Non-real time Hydraulic Model Review Template
Environment Agency, Defra
Template
LIT 17617
6.0
OFFICIAL

NON-REAL TIME HYDRAULIC MODEL REVIEW

Project	Barnham Eastergate Westergate BEW Parcel SC1 Barnham	Job Number		Required coastal standard (if applicable)	
---------	--	------------	--	--	--

Model Type	1D/2D	Software	Other	2nd review	3rd review	4th review
Revision	1	Date	27/03/2023	08/06/2023		
Area Client		Reviewer	Jacobs	FT

SECTION A-A
SCALE 1:100

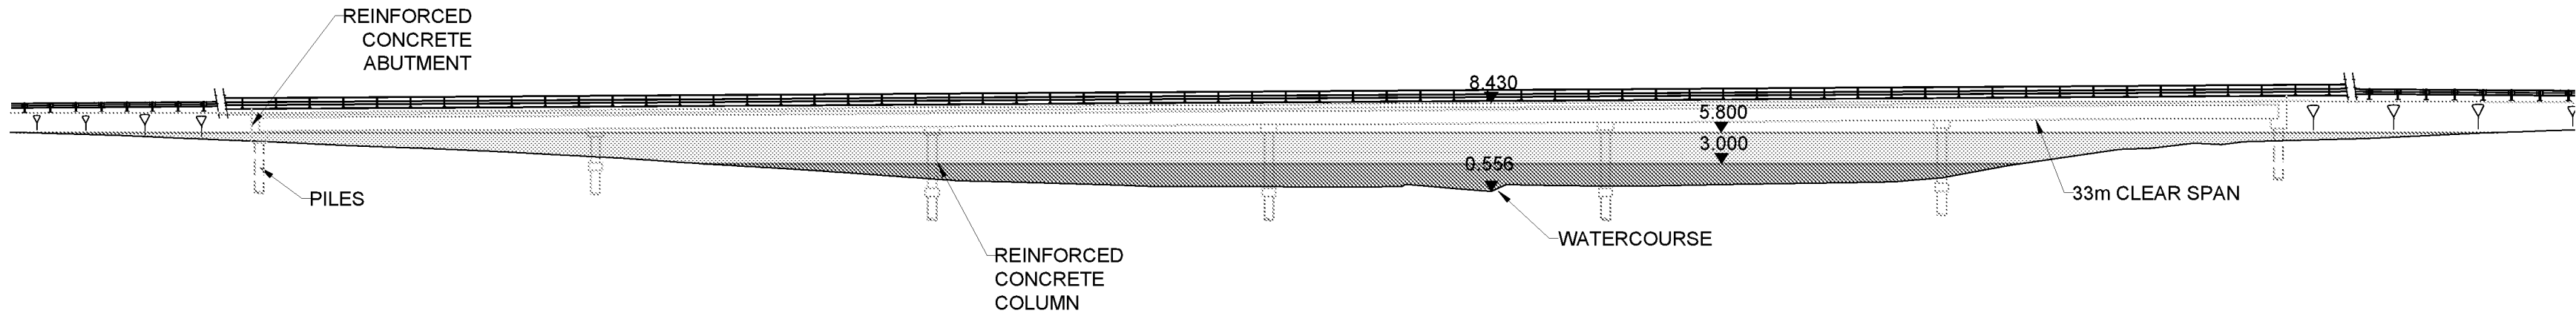
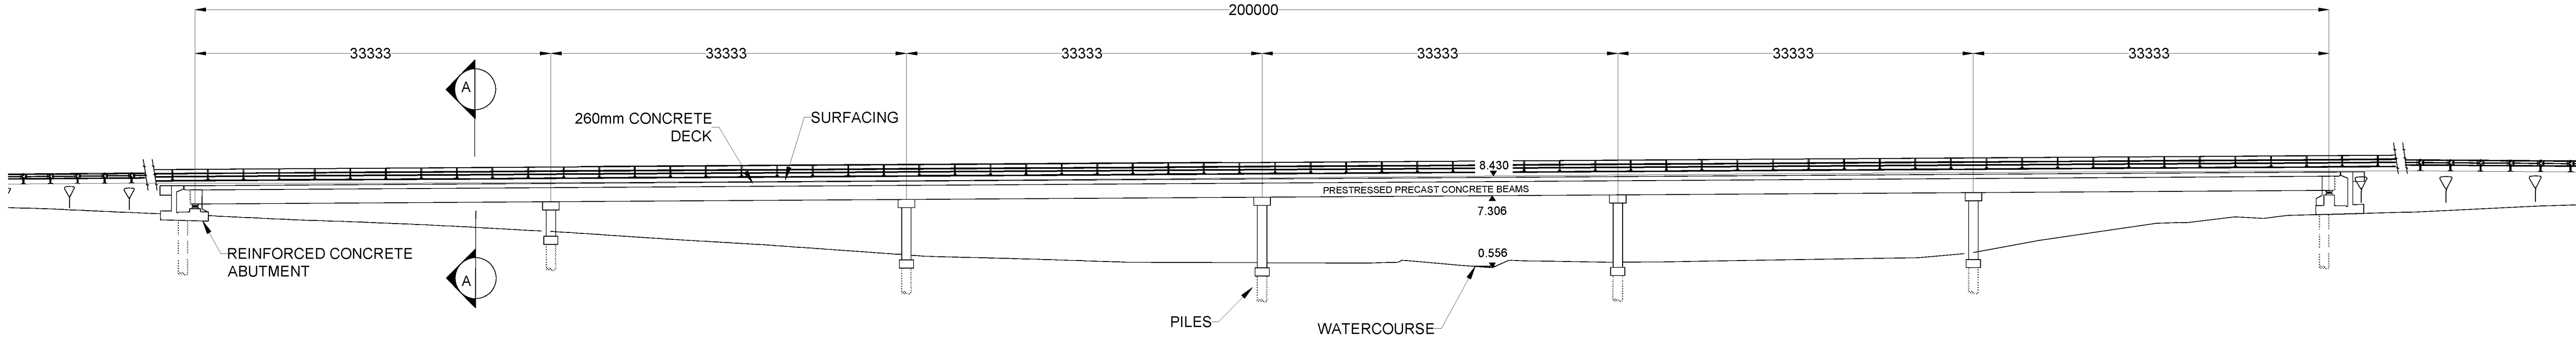
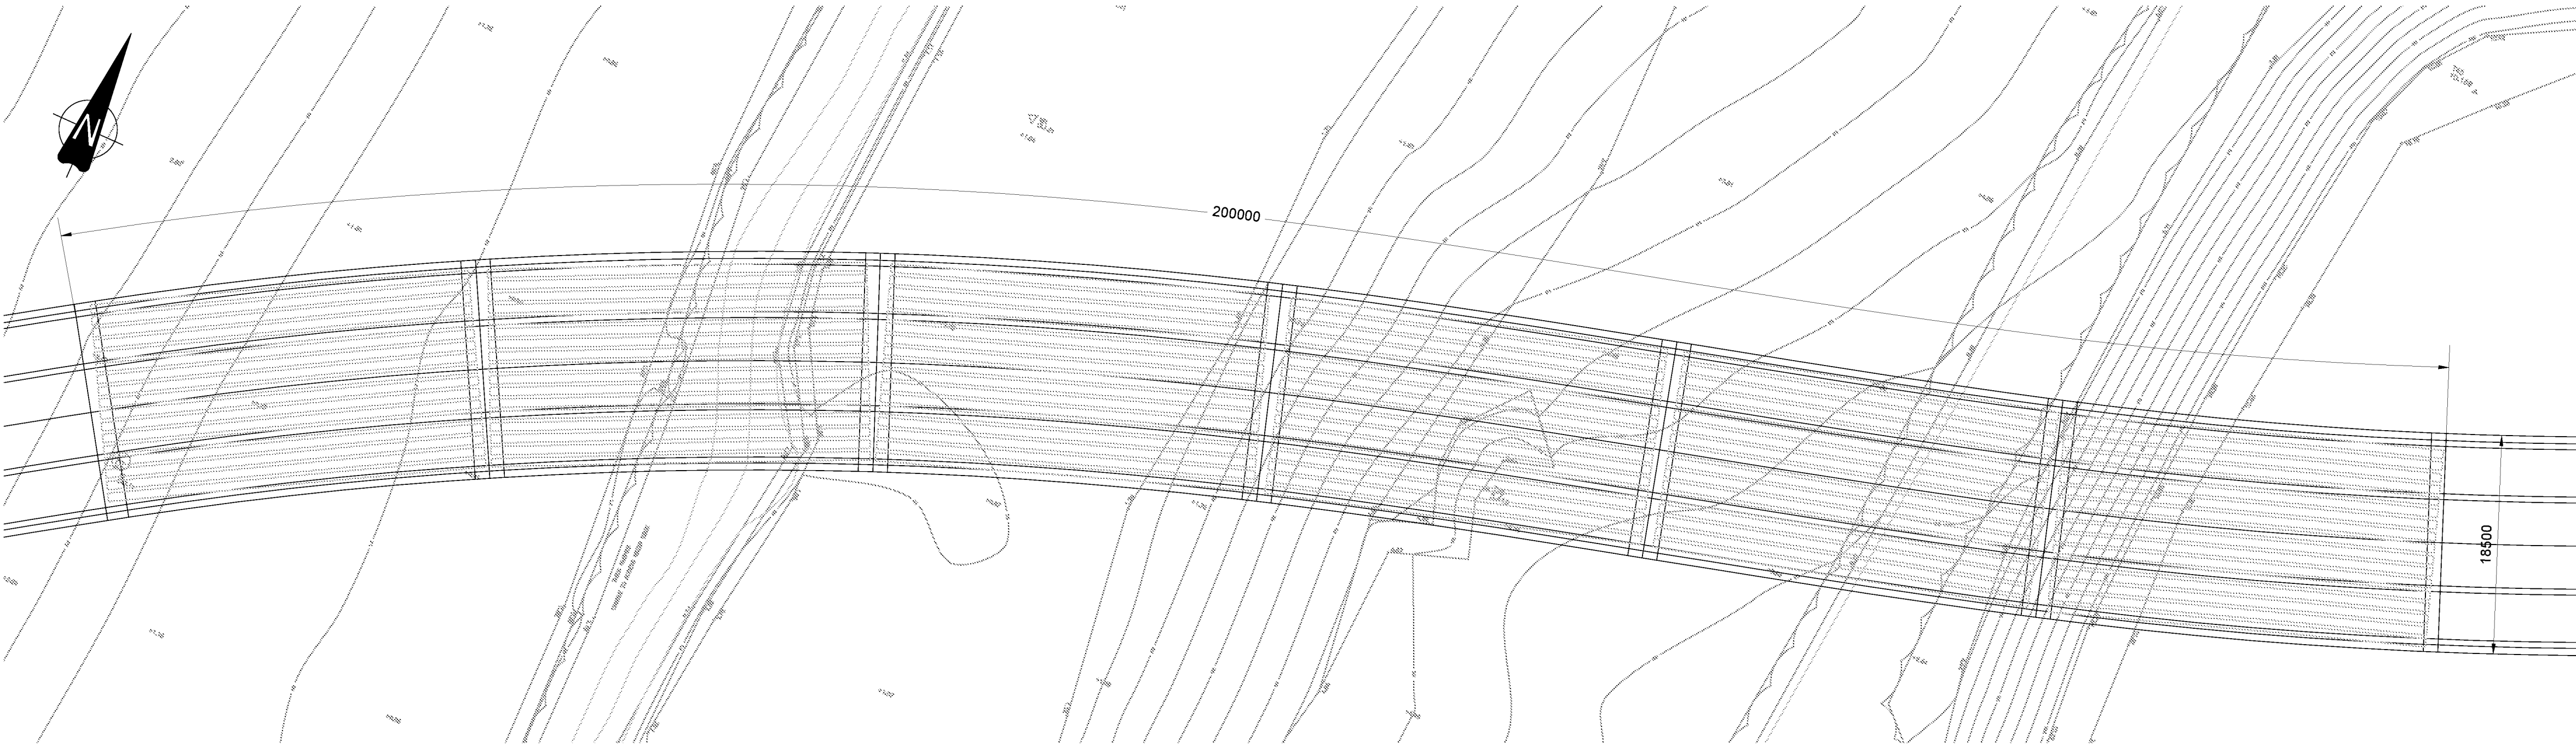
7.9	Are defences/embankments/bank crests accurately represented?	N/A	No defences in the area of interest				
7.10	If post-development scenarios are required have the proposed ground levels and building been represented appropriately?	Red	The Flood Risk technical note provided some context information on the proposed A29 re-alignment. The information provided is limited and makes reference to model results that are not consistent with the model results made available for this review. Porous polygons (fully impermeable) have been used to represent the proposed embankments for the bridge. No design information has been provided to verify that these have been placed at the right location. A multi-span scenario has also been provided, but there is no reference or description of this in the Flood Risk Technical Note. The proposed scheme site boundary indicates other works being proposed (Including near Lidsey Road and the road leading to Lidsey Oil Field). No information is provided for the rest of the scheme and therefore, it is not possible to confirm if the post-development scenario has been represented correctly.	More information on the proposed development needs to be provided (e.g., technical drawings) in order to confirm the representation of the scheme,	The location and elevation of the bridge abutments for the single-span scenario are based on drawing 13394-PEF-ZZ-XX-M2-S-000002 prepared by Pell Frischmann. The location of the bridge pillars for the multi-span design is based on drawing 13394-PEF-ZZ-M2-S-000003, prepared by Pell Frischmann. The purpose of the study is to assess the impact of the abutments and pillars of the two bridge scenarios on the flood extents in regards to depth and coverage. The two scenarios are compared against the baseline model which has been provided by the EA	OK	Porous polygons on left and right banks to represent embankments in proposed scenario. Multi-span scenario includes bridge piles set to an elevation of 7.306mAOD with east and west banks set to 8.430mAOD. Note that 8.43mAOD corresponds with the bridge deck, 7.306mAOD corresponds with the soffit level as per technical drawings. Distance between piles aligns with technical drawings.
